## **Able Marine Energy Park**

### *Material Change 2*

**Statement of Common Ground**

**ENVIRONMENT AGENCY**

Figure 8-12: Changes in predicted significant wave height with disposal sites HU081 and HU082, MSL
(Contours in blue indicate a decrease; contours in red an increase)

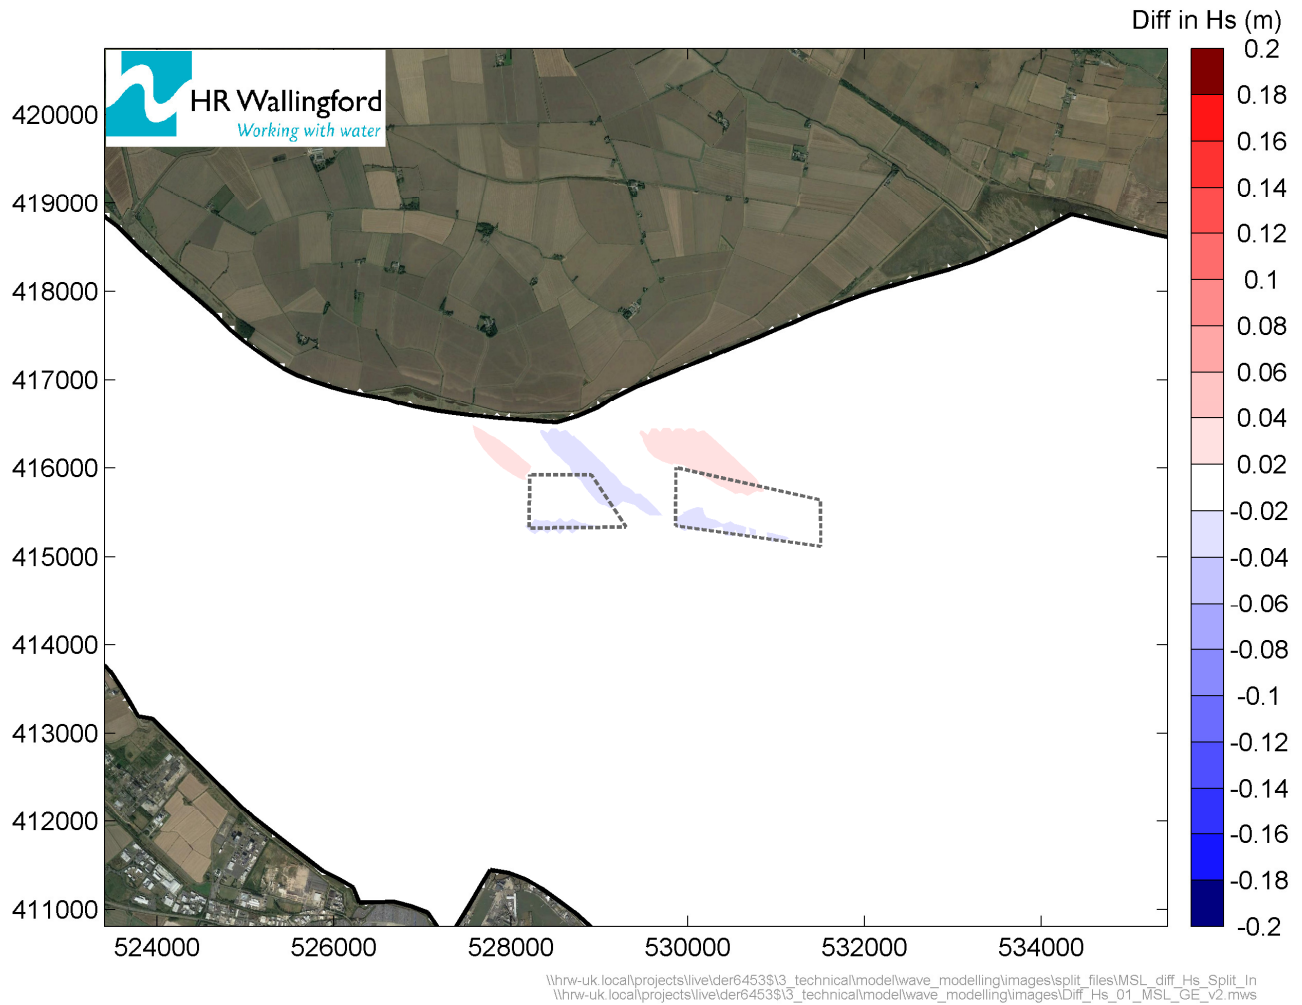
Comment by	Para.	Comment	ES Ch 8 Section (if noted)	HR Wallingford response
Environment Agency	4.1	<p>Impact of changes to hydrodynamics on Hawkins Point (Section 8.4.36 onwards):</p> <p>One wave condition was chosen to carry out this assessment, but it is not clear why this particular condition, and only one, was chosen. We, therefore, request more clarity on this in order to provide confidence in the conclusions reached.</p>	8.4.36 onwards	<p>The nearshore wave rose for Hawkins Point (from The Humber Tidal Database and Joint Probability Analysis of Large Waves and High Water Levels Annex II, ABPmer (2007) report for the Environment Agency) is shown below.</p>  <p style="text-align: center;">Wave rose for Hawkins Point</p>

In line with the original ES submission, to assess the potential changes to waves resulting from disposal activities (now at both HU081 and HU082), waves entering through the mouth of the estuary were selected. The value selected was Hs 1m, Tm-10 = 4s, and direction 135 degrees was considered appropriate to capture the effects on larger waves (which will “feel” the seabed at deeper depths than smaller waves) of the disposal mounds. In terms of why other directions were not selected, it is seen from the table and wave rose above that a) 60% of all wave energy (including much smaller waves) is predicted to be incident from between 110 and 150 degrees, and b) almost all waves of Hs = 1m and above are incident from this direction.

This single wave direction of 135 degrees was therefore representative of these incident waves. Importantly, the waves were also modelled for three different water depths (as per the original ES). For these larger Hs = 1m waves from 135 degrees, the predicted changes to wave height are negligible for MHWS, approximately +/-2cm for MSL, and approximately +/-5cm for MLWS.

Figure 8-15: LiDAR images of Hawkins Point from 2000 (top) and 2019 (bottom) showing extracted cross-sections

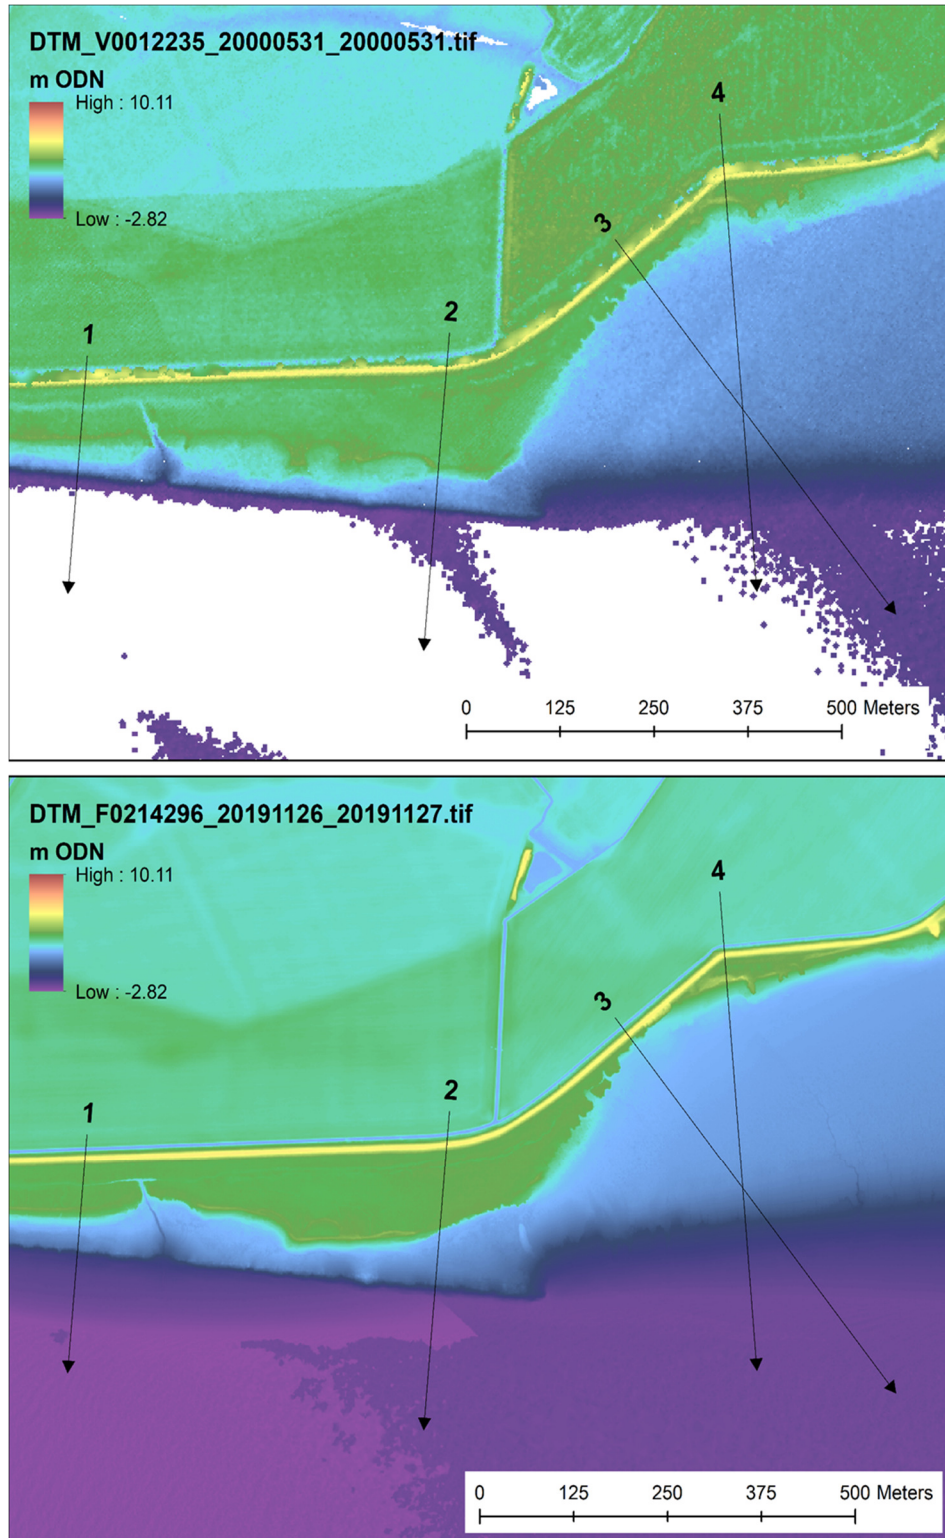
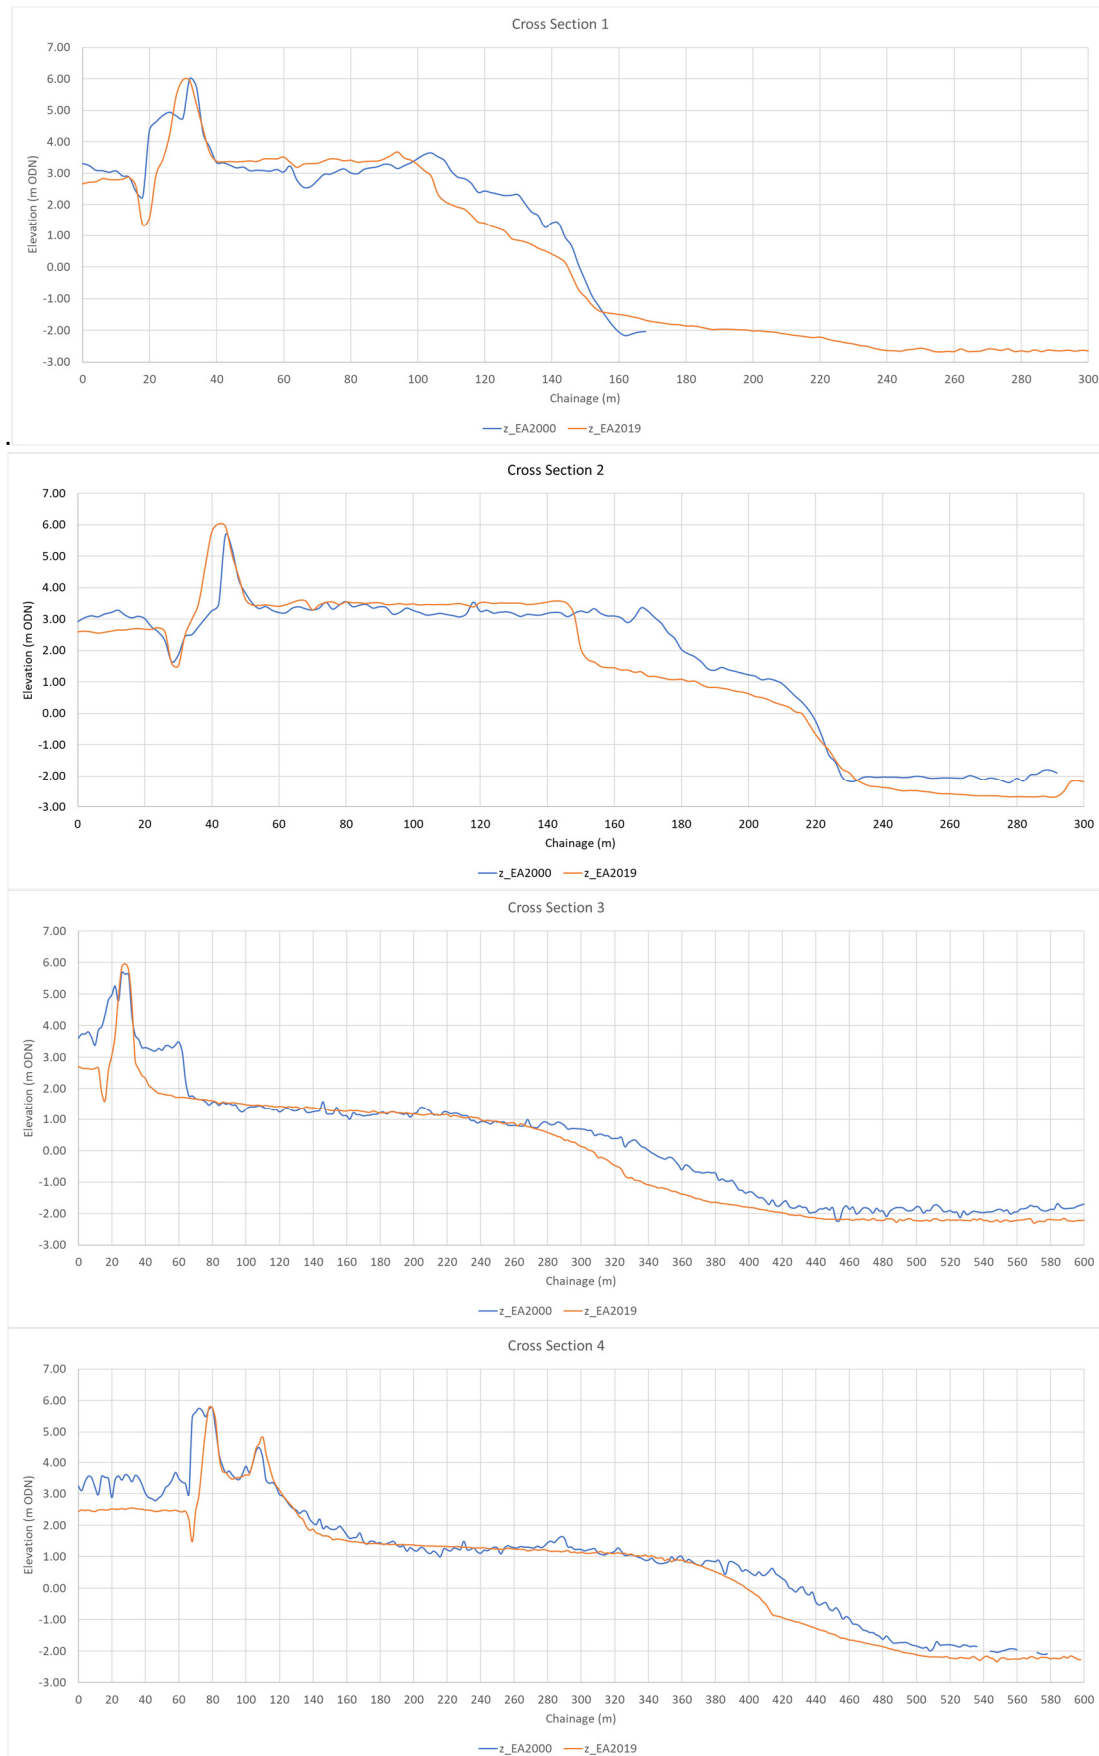
4.3	<p>If these points can be clarified, the conclusion that there is limited impact on the currently eroding section seems reasonable. However, this assessment does also indicate some increasing wave activity which could result in foreshore erosion to the west of Hawkins Point (8.4.39). Whilst this section of the foreshore is currently stable, the potential impact here needs some further consideration in regards to risk to habitat/flood defences.</p>		<p>For a combination of high waves with a high sea level there is negligible change to the wave heights and therefore likely a negligible effect on flood risk. For lower sea levels, changes to wave heights, as noted above, are +/- 2cm at MSL and +/-5cm at MLWS.</p> <p>It is worth noting that these impacts relate to the two disposal sites conservatively being assumed to be filled to the -5.3mCD limit, when in reality it is expected that the post-construction level will be lower than this.</p> <p>The predicted changes to waves are within the natural variability of incident wave conditions. The predicted changes are transient (they will diminish with the dispersion of disposed material from HU081 and HU082) and are expected to last for a few years.</p> <p>Overall, for the above reasons, there is considered to be no increase to flood risk.</p> <p>Analysis of historic change of profiles derived from LiDAR data running across the low intertidal up to the elevation of marsh level have shown that to the west of Hawkins Point the lower intertidal of the foreshore is relatively stable, unlike that to the east of Hawkins Point. Whilst it is recognised that at MLWS and MSL there are small increases in wave heights (see above) it is not considered that such small increases will lead to significant erosion of the lower foreshore which appears currently to be stable. The increases are likely to be insignificant within the natural variability of the incident wave conditions.</p> <p>If this foreshore were presently subject to erosion a small increase in such erosion might be anticipated for the few years that it will take for the glacial clay to disperse from the disposal sites. However, given the relative stability of the lower foreshore to the west of Hawkins Point, it is unlikely that the small predicted increase in wave height at lower water levels will be sufficient to instigate a trend for erosion.</p>

Figure 8-39: Recent changes to local bathymetry and intertidal levels (difference shown in metres with positive or red showing accretion)

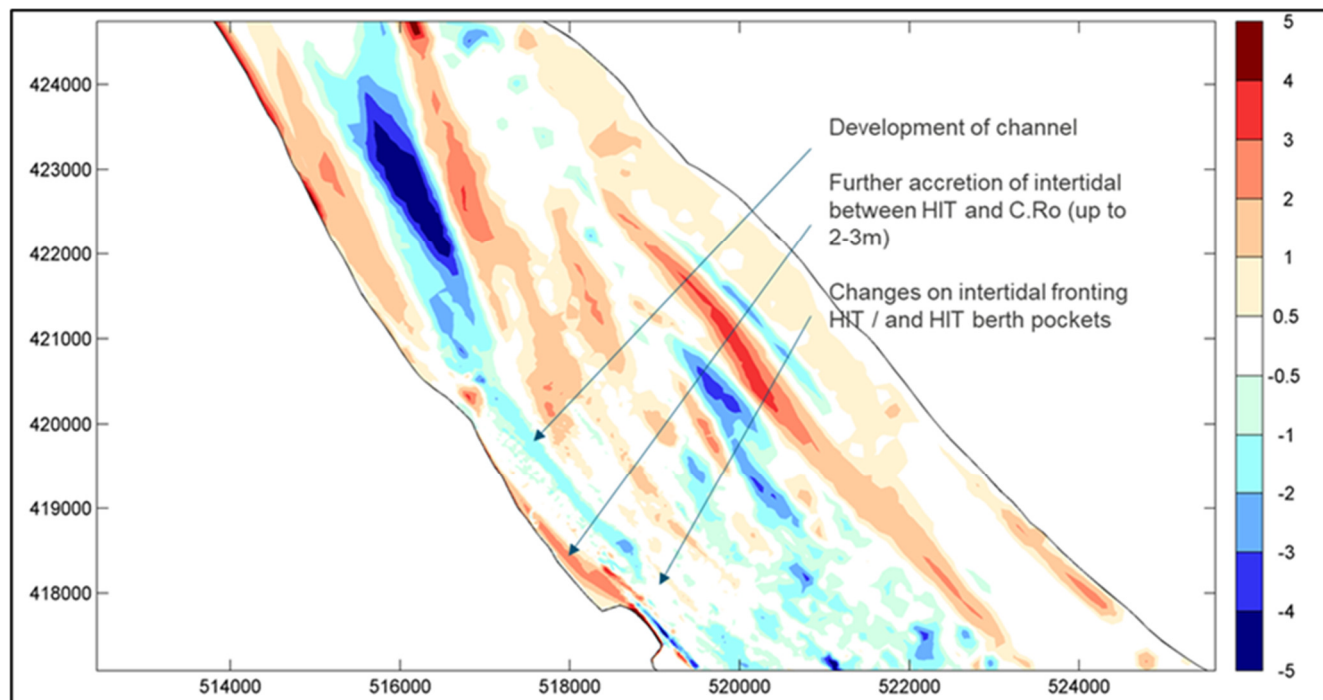
4.9	<p><i>Minor comment</i></p> <p>There is a typo in paragraph 8.4.69 where Figure 8.39 is erroneously referenced as 8.40.</p>		Noted. Thank you.
